Reference is made to the letter sent by the Department of Planning & Infrastructure inviting the NSW Heritage Council to provide a submission on the Environmental Assessment (EA) for the Macdonaldtown Gasworks Remediation Project (MP 09_0145), which is currently on Public Exhibition.

Accordingly, the Heritage Council has considered the Environmental Assessment and the relevant Appendices for this project and provides the following comments:

Figure 25: Macdonaldtown interpretative device locations (from City Plan Heritage 2010b)

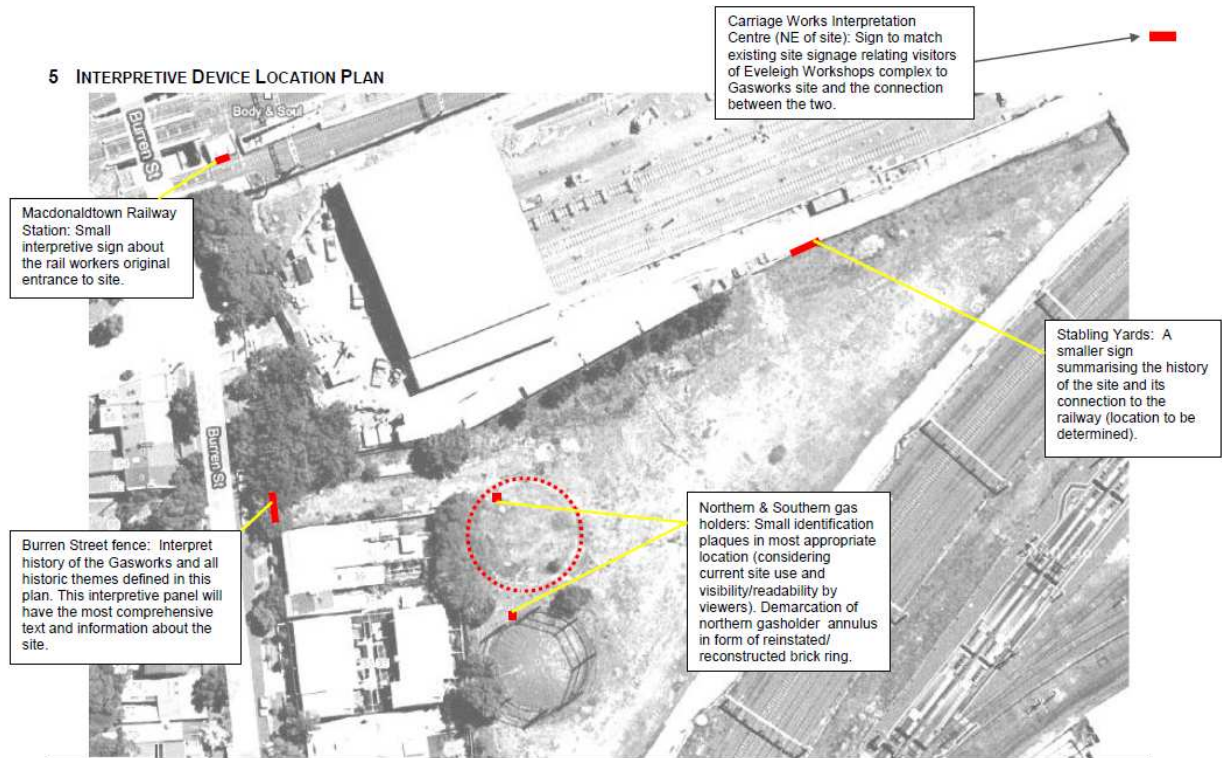
- b. In **Commitment H4**, the Applicant agrees to install Interpretive Signage as per the Interpretation Plan in various locations, including Macdonaldtown Railway Station. The Heritage Council considers that the location of the single Interpretation Panel proposed at Macdonaldtown Railway Station (as outlined in the Interpretation Plan) is inappropriate, as the planned location is unlikely to encourage commuters to take the time to stop and engage with the interpretation.

- The Heritage Council requests that **Commitment H4 is amended** to allow for several panels exploring the history of the gasworks to be provided along the railway platform in appropriate locations to allow commuters to understand the history of their local area.
